Comments by F.J.R.Brown IP No. 20044329  
For submission by Deadline 3  
of the EN010117 Rampion Wind Farm Examination

This is a response to the Applicant's Deadline 2 Document 8.53 Category 8 Applicant's Response to Non-Prescribed Consultees' Written Representations- Appendix C

## **Comments on some of the Photo Montages and figures in Chapter 15**

Figure 15.32d  
 Viewpoint 7: Beacon Hill Rottingdean

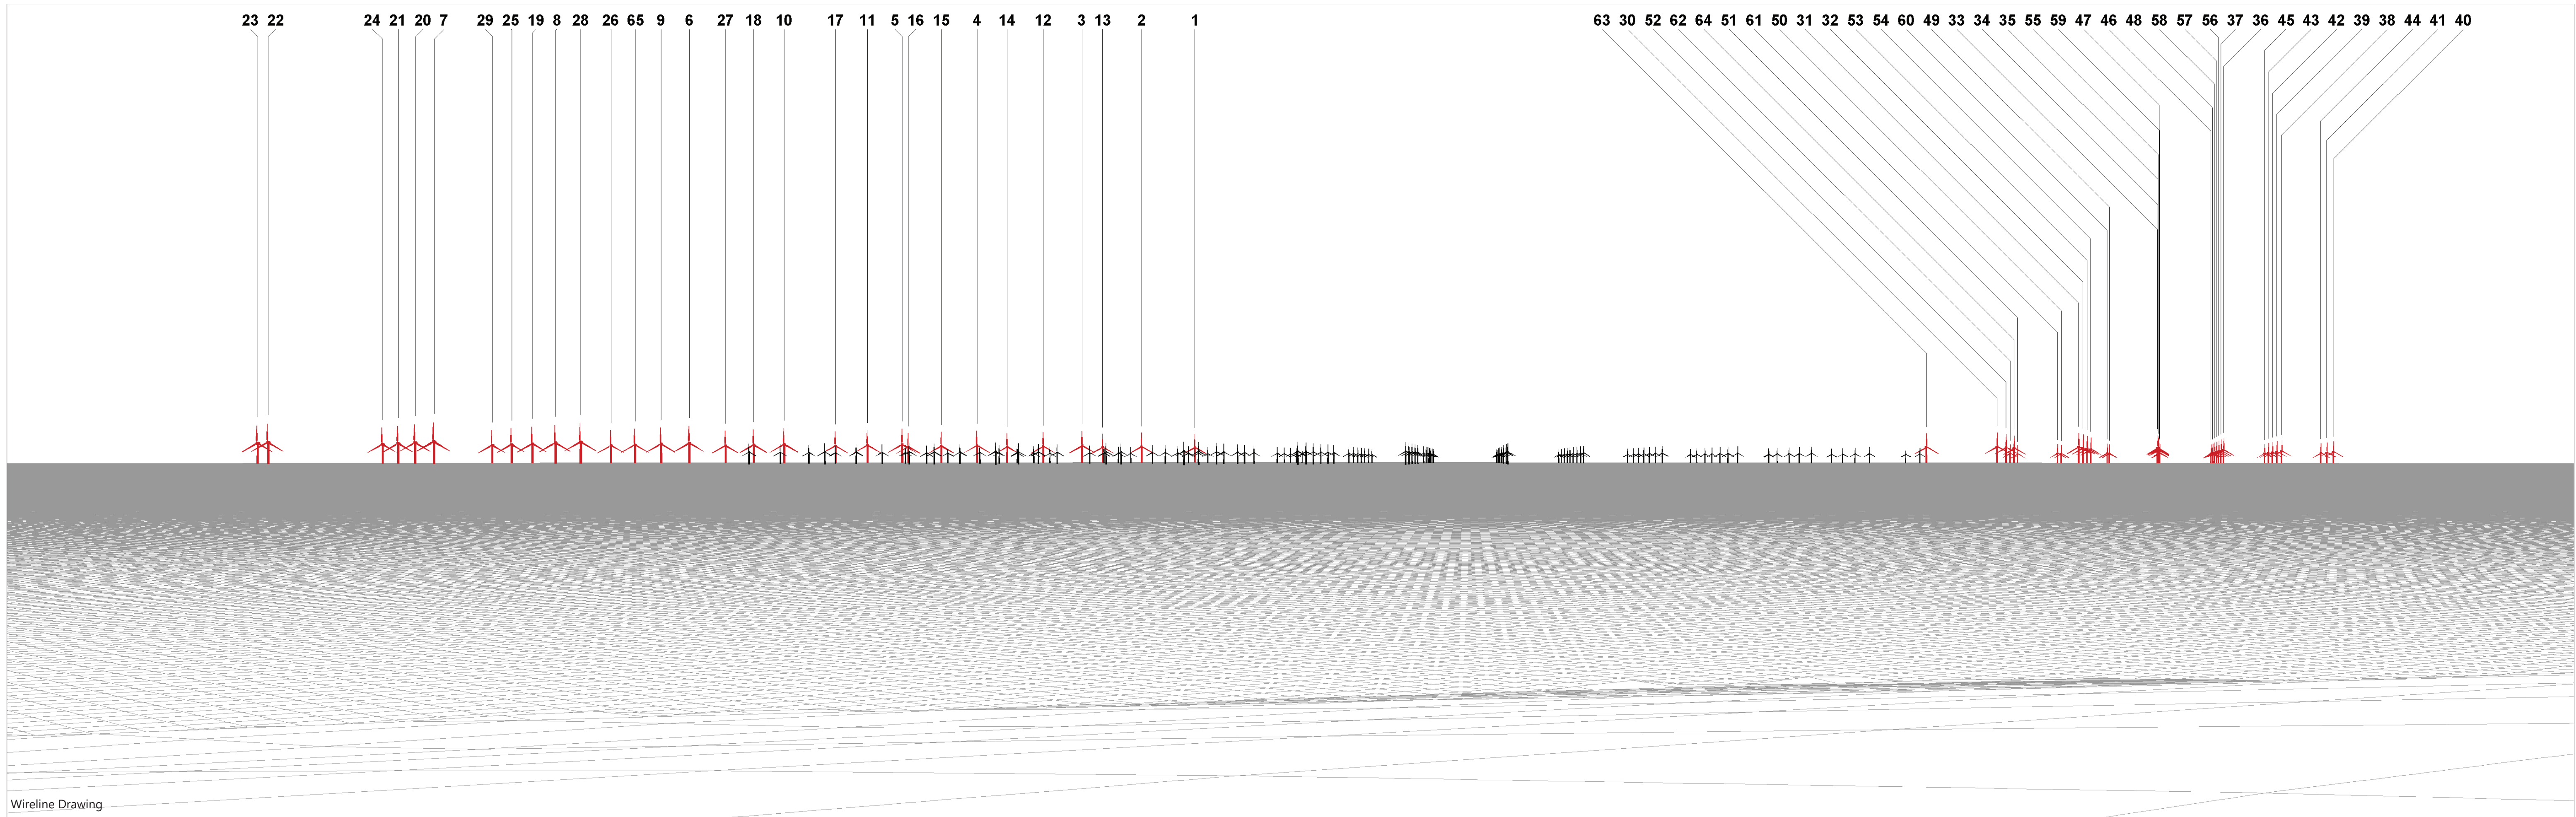
### **Figure 15.32a-f Viewpoint 7 Beacon Hill, Rottingdean**

Indicates just how intrusive and outlook-altering the turbines are from higher viewpoints – even at 21.12 kilometres (which of course is less than the 33-40km recommended by OESEA4)

Figure 15.34g  
 Viewpoint 9: Shoreham A259 coastal road

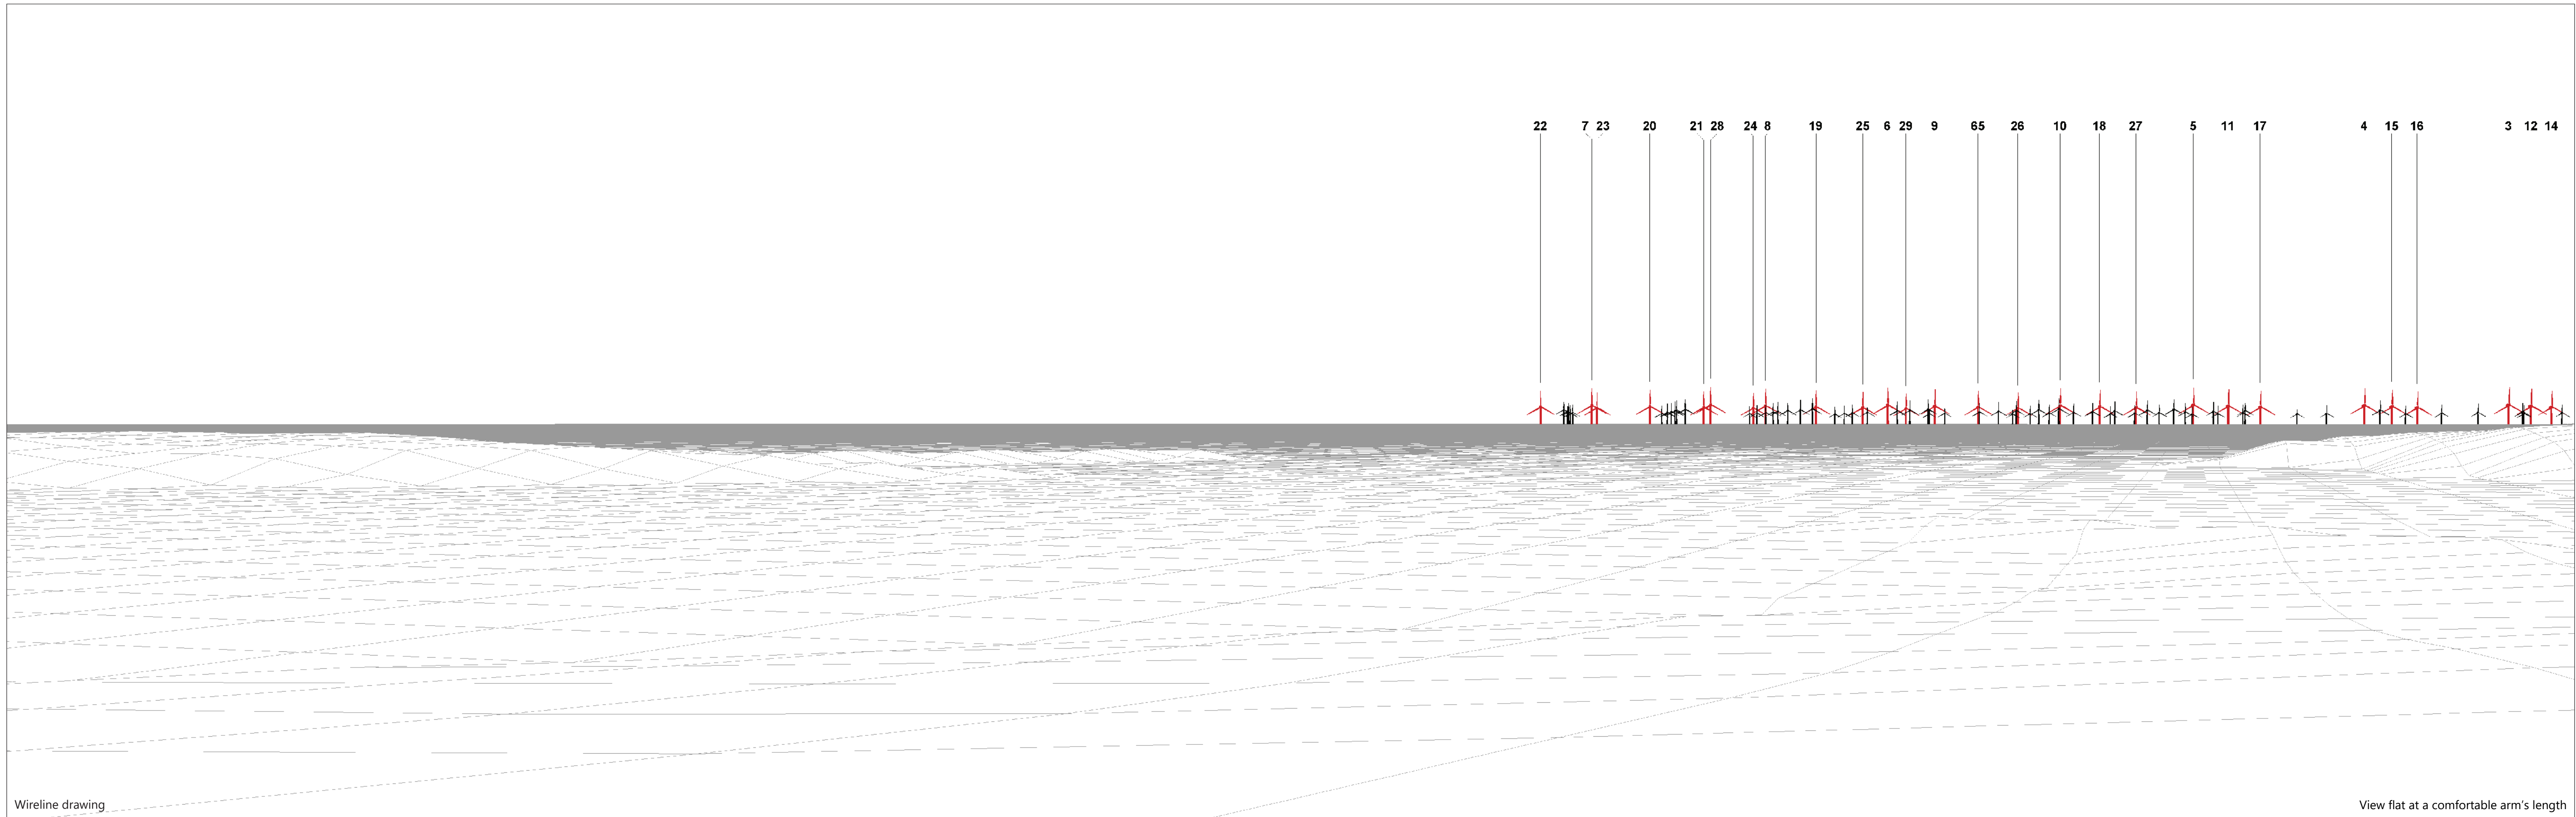
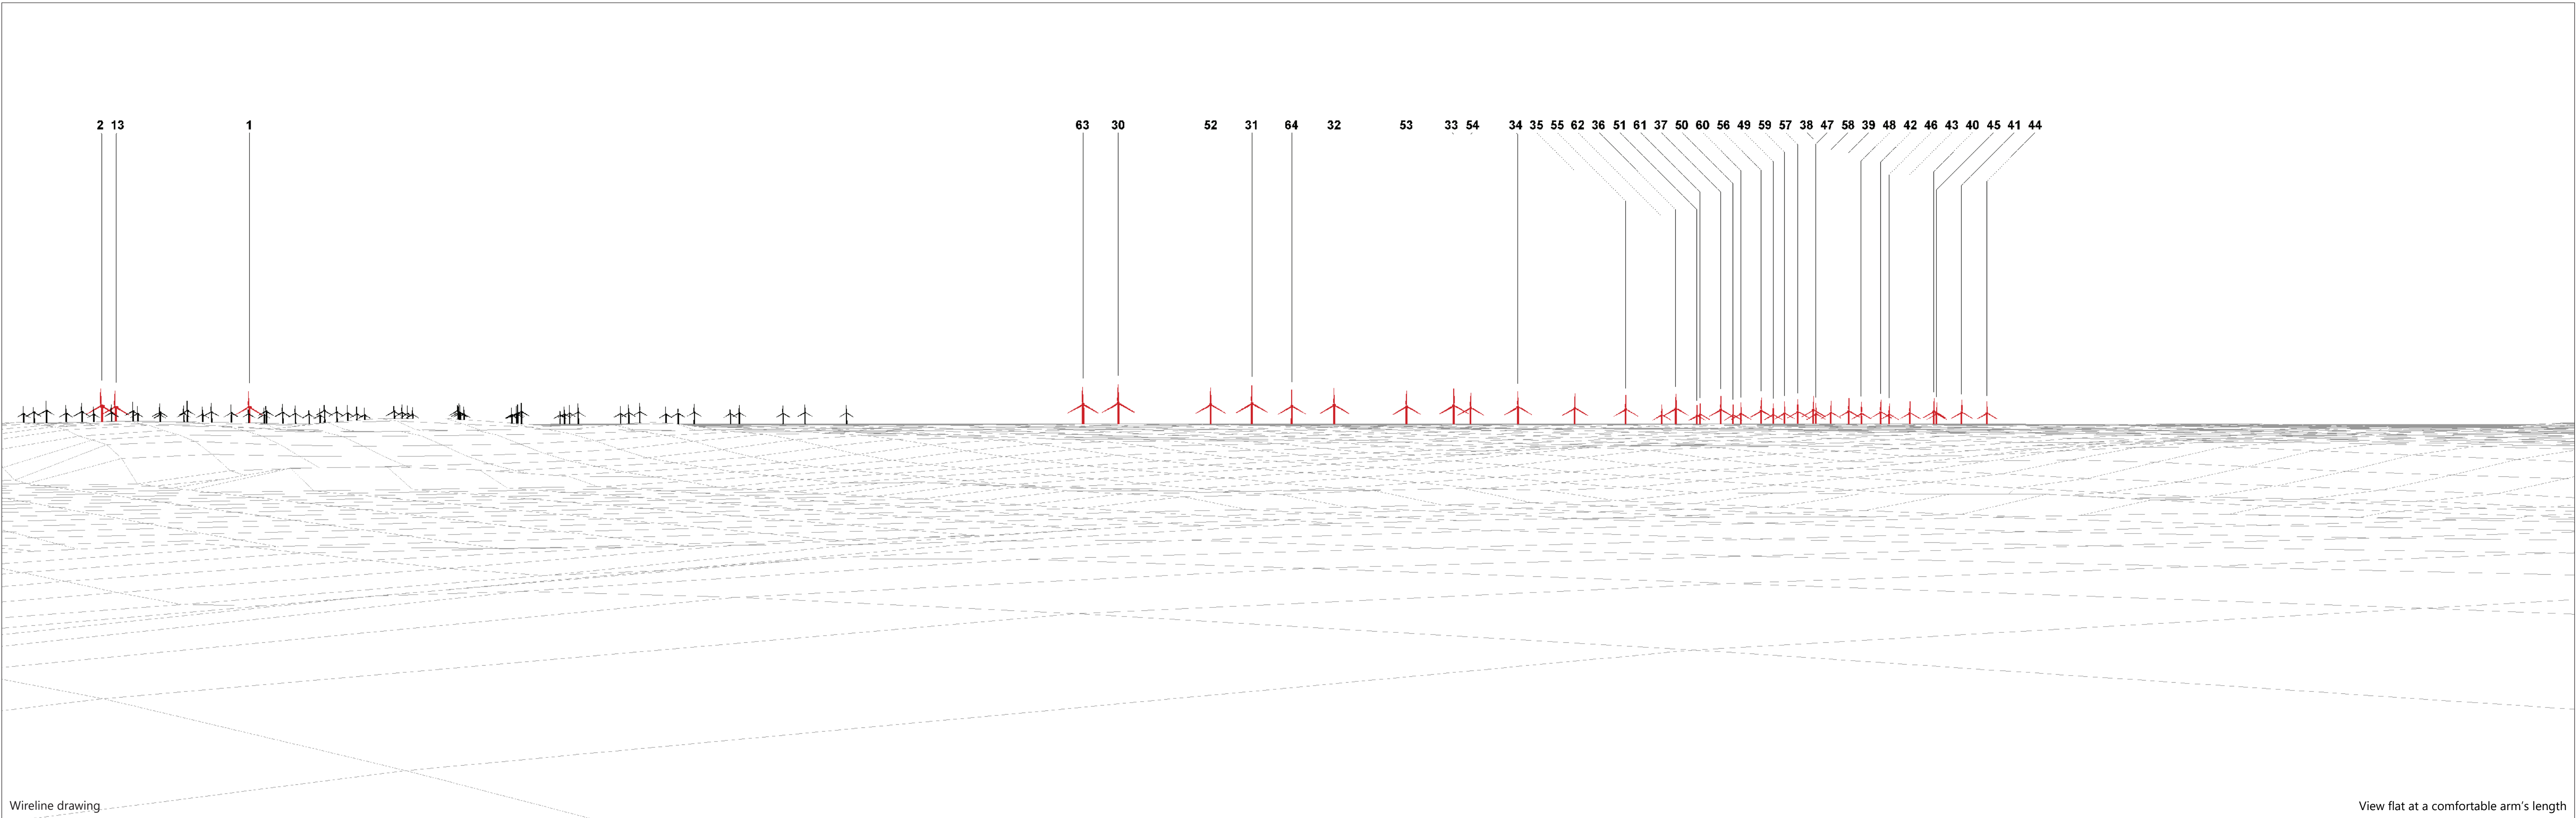
### **Figure 15.34a-I Viewpoint 9 Shoreham/A2 59 coastal road ((Kingston Buci)**

This seems an eccentric choice of viewpoint given that the offshore shingle bars of the Canal and Shoreham Beach, together with the Harbour Arms, obstruct the line of vision from road level. Locals know this and tend to head for the Fort at the end of Shoreham Beach (clearly visible just to the right of the Coastguard Lookout on the West side of the harbour entrance) to get uninterrupted views of the sea.

Figure 15.35h  
 Viewpoint 10: Worthing sea front promenade

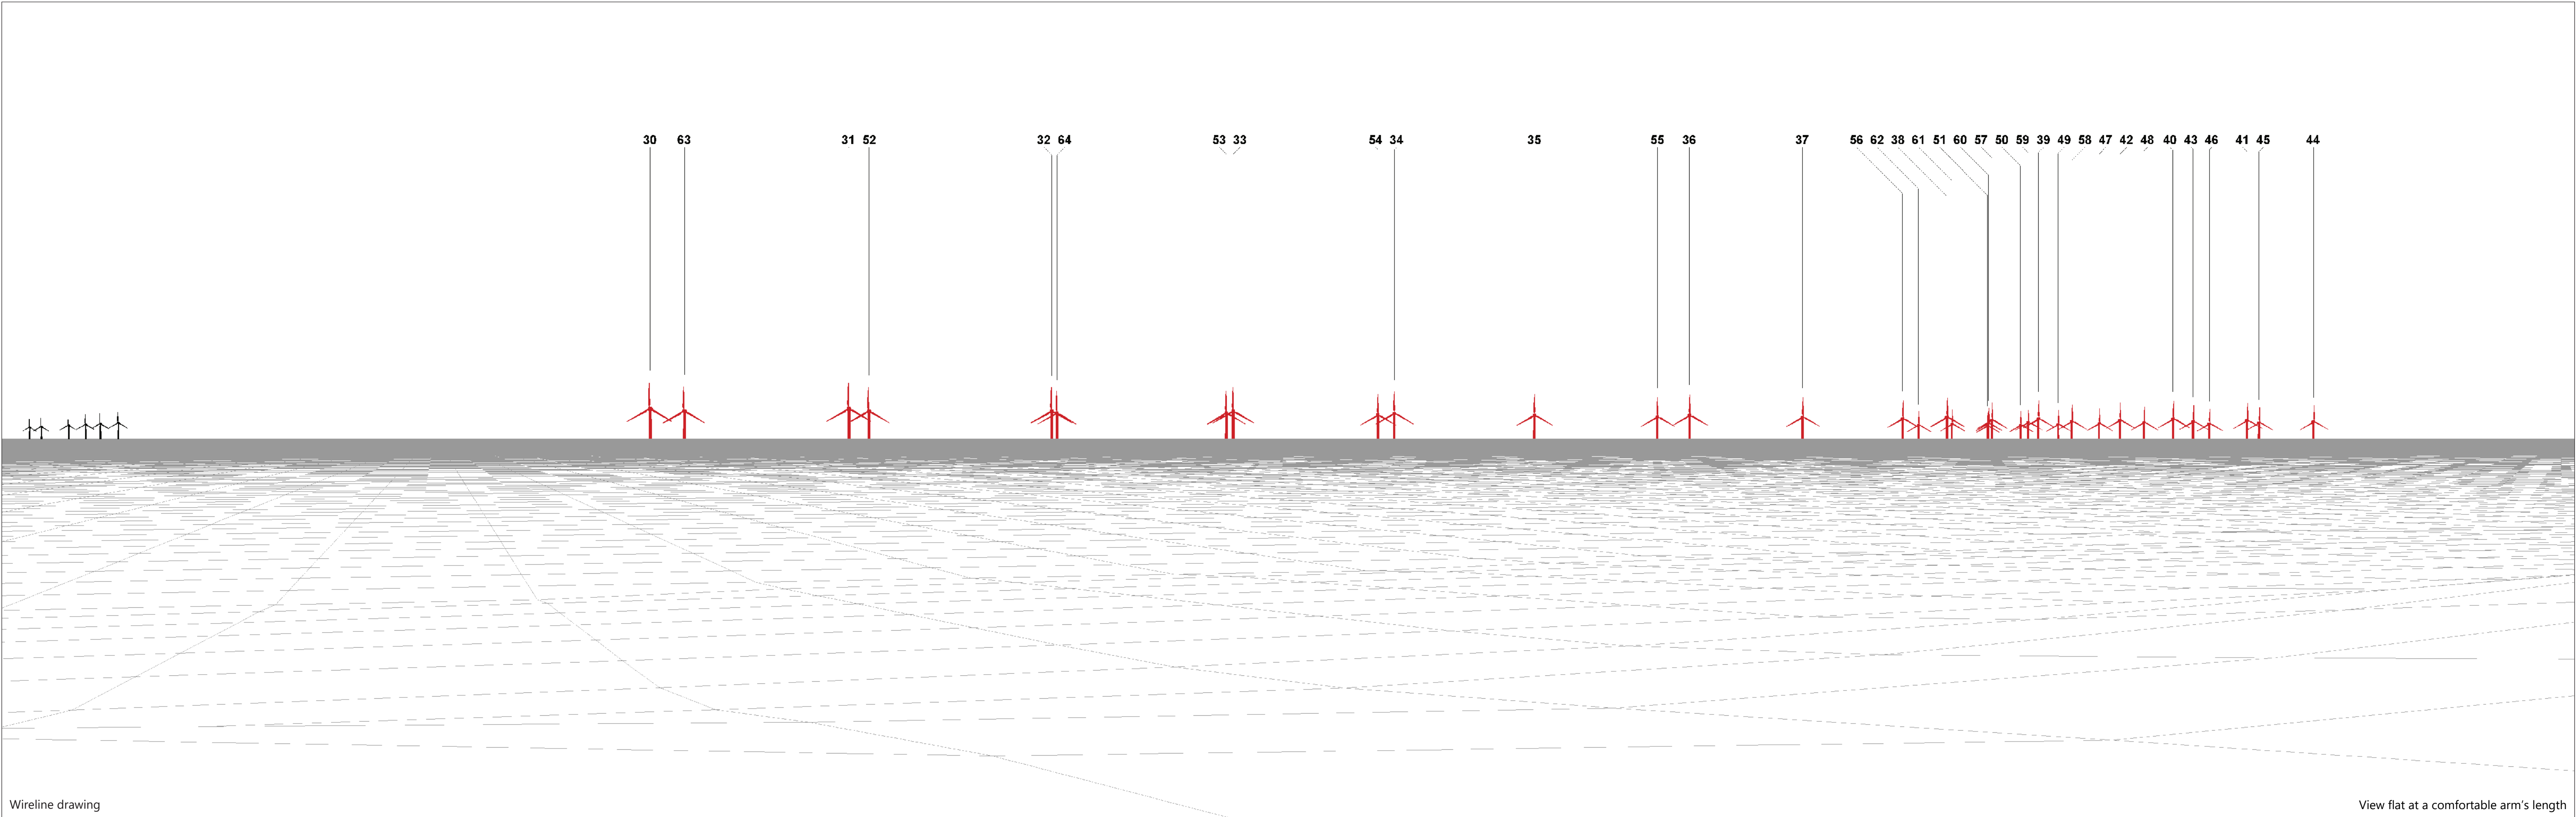
### **Figure 15.35a-I Viewpoint 10 Worthing seafront promenade**

Illustrates well the abrupt dramatic change in size of the Rampion 2 Turbines at the western end of Rampion 1
